**KIRKLEES METROPOLITAN COUNCIL
INVESTMENT & REGENERATION SERVICE**

Reference No: 2021/62/90417/W

Site Address: 68, Newsome Road, Newsome, Huddersfield, HD4 6NQ

Description: Erection of two storey extension to rear

Proposed Left Side Elevation

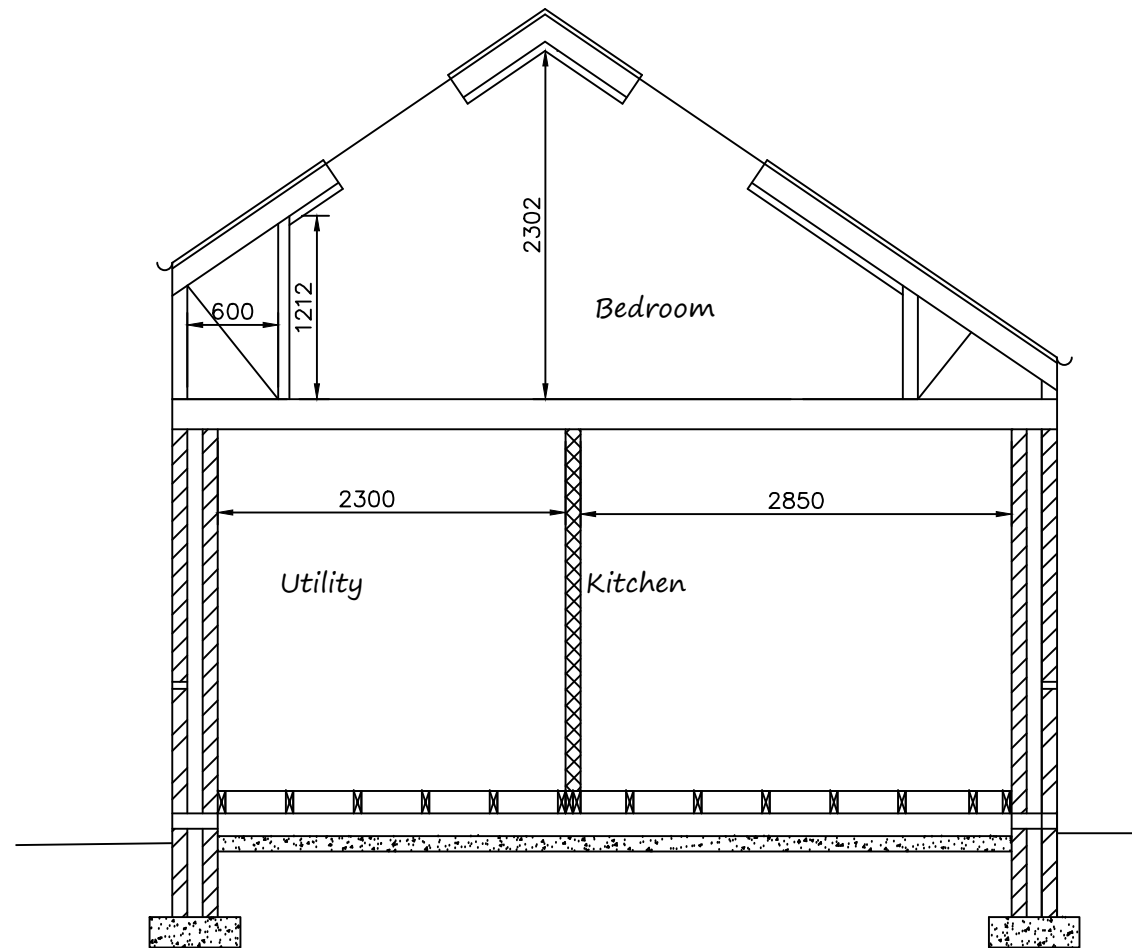
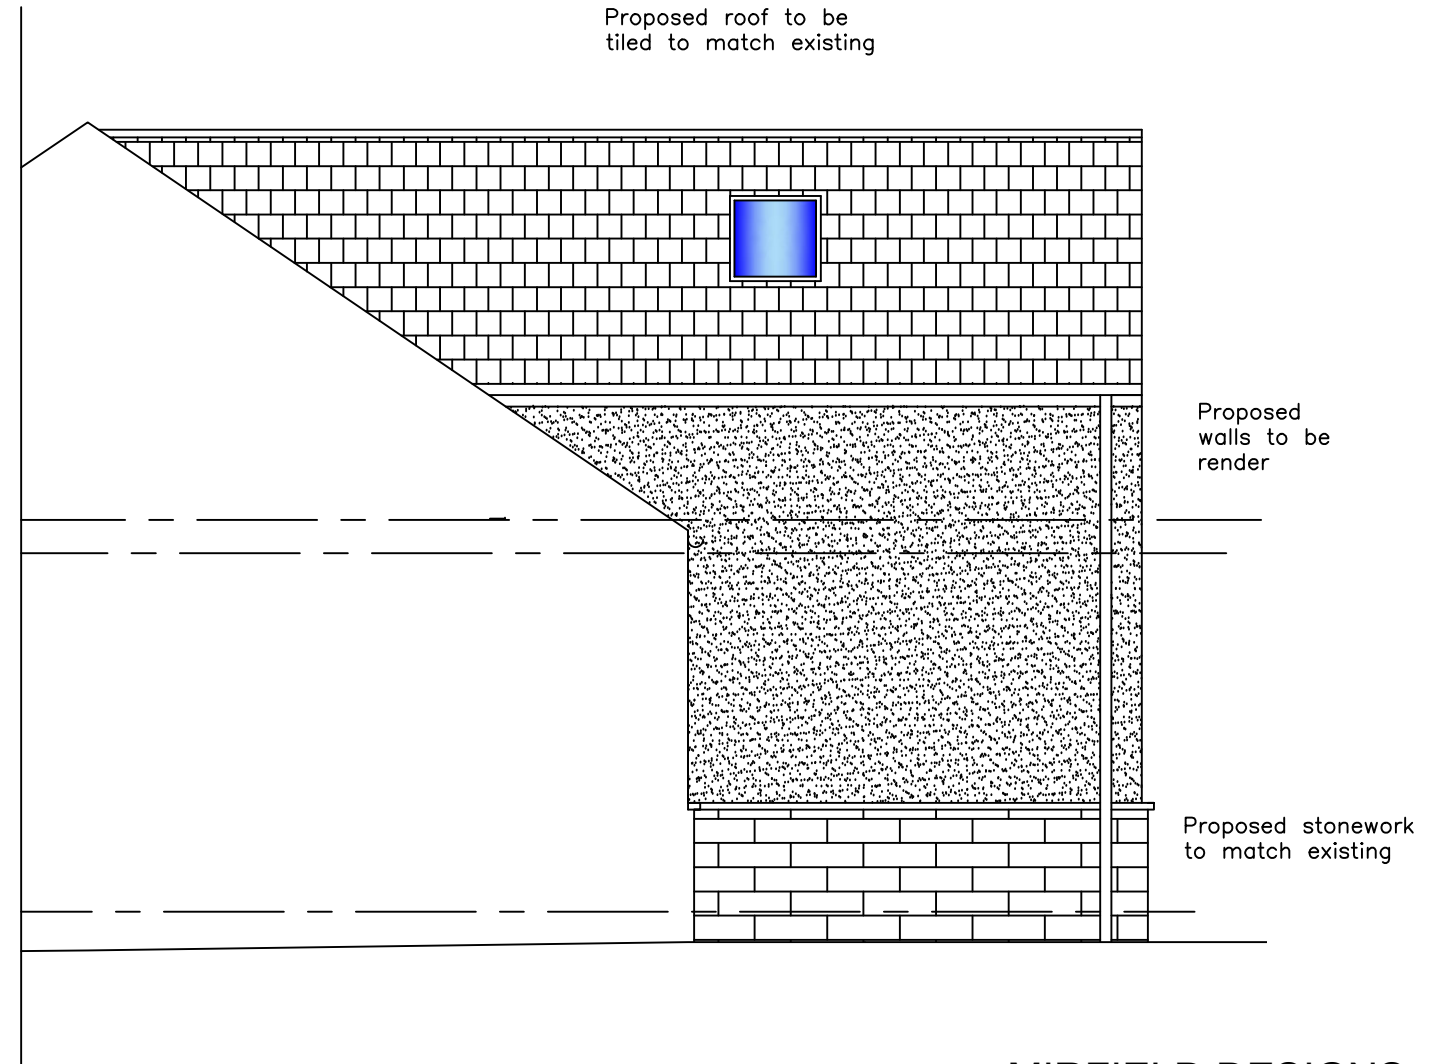
The extension would be located on the rear elevation of the property and would be 2 storeys in height to enable additional accommodation to be created within the roof space. Due to the overall scale and height of the extension resulting in a two storey structure the extension would result in the loss of character of the existing ‘true’ bungalow. Whilst it is recognised that the roof line would match the existing, the eaves heights differ on each side of the extension with both eaves set up from the existing eaves which appears at odds with the existing host property. The design, scale and mass does not sit well with the host building. It is therefore considered that harm the visual amenity of the host building with an extension that would be incongruous with the appearance of the bungalow and surrounding development. This is

Proposed Rear Elevation

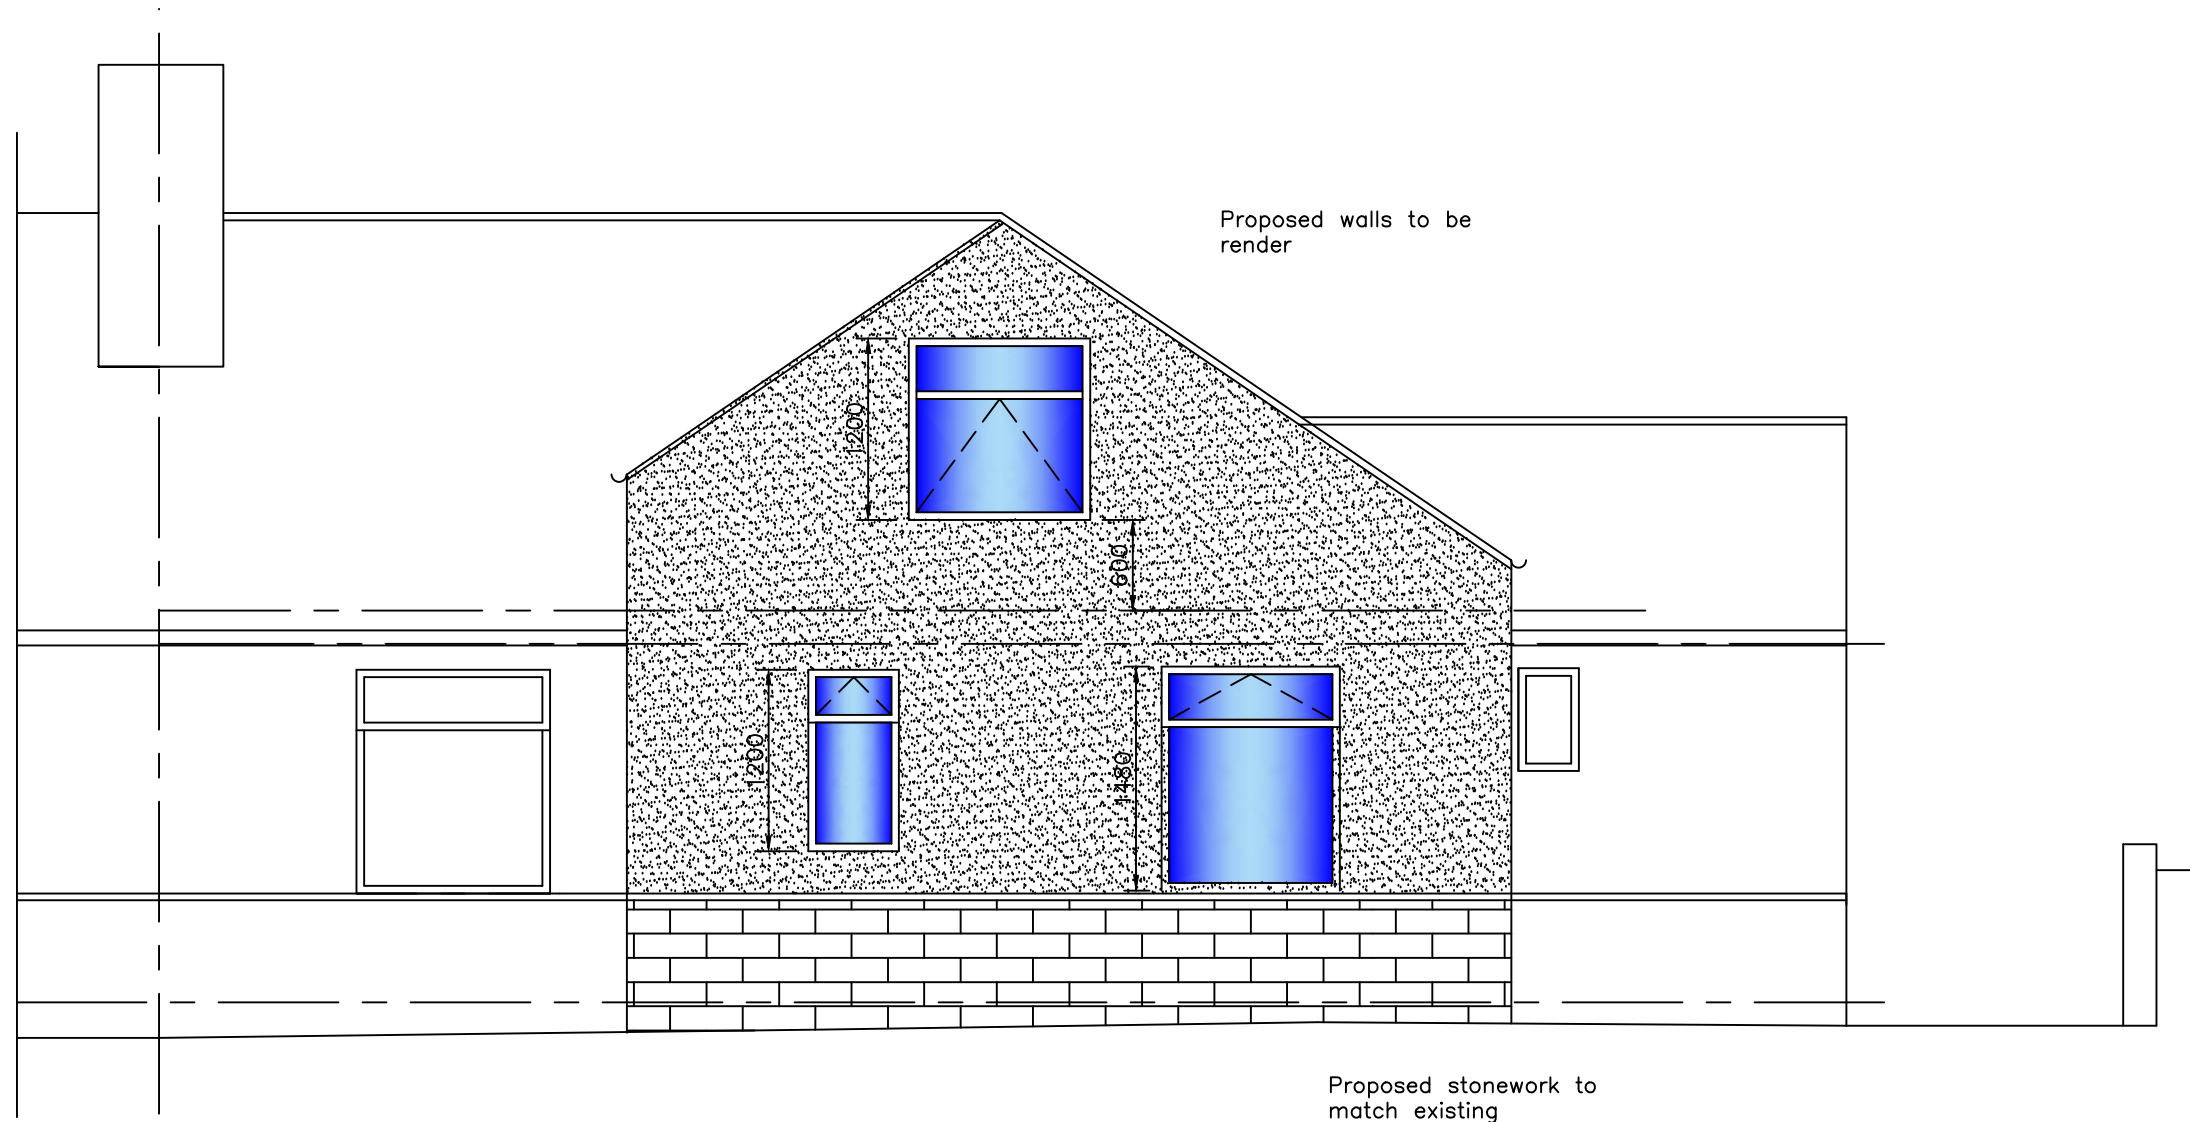
emphasised further when viewed from the rear where the land levels are higher and where the extension would appear out of proportion.

Openings would be located within the ground and first floor of the rear elevation, side elevation facing No. 70 at ground floor and rooflights are proposed within both roof slopes. In terms of the impact from the rear elevation openings, these would overlook the garden area of the property and therefore raise no concerns. The patio doors within the ground floor of the extension facing No. 70 are also considered to be acceptable given the 'fall back position' being that a single storey extension could be constructed with the same openings without the requirement of planning permission. It is not anticipated that significant harm from overlooking from the roof lights.
